# Work Change Proposal Request

PROJECT: Nephrology Associates Renovations  
Portland, Maine

## Code Clarification Revisions

DATE OF ISSUANCE: 2/16/2012

**DOOR & DOOR FRAME SCHEDULE**

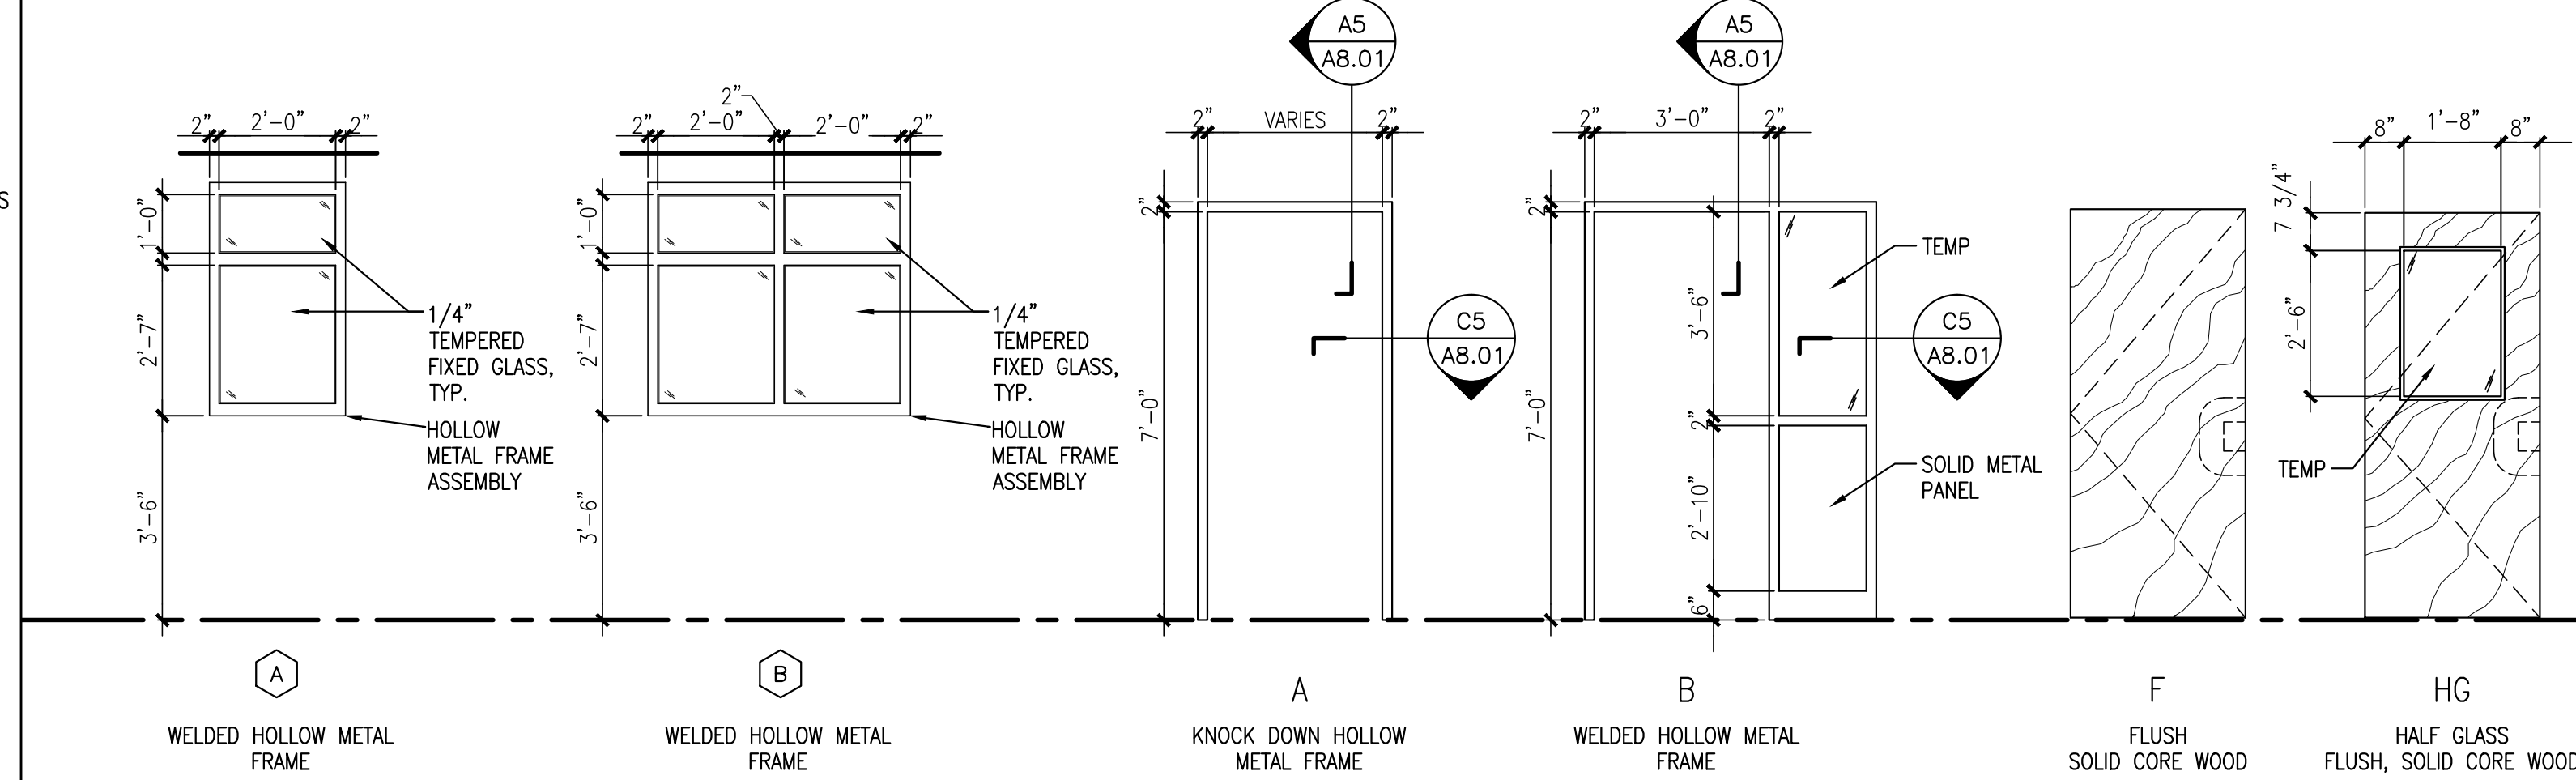
Item No. 1: The contractor shall revise the fire rating of all new doors within Corridor 152 from 45 - minute doors to 60 - minute fire rated door units. This applies to doors 151B, 152A, 152B, 152C, 152D, 152E, 152F and 143.
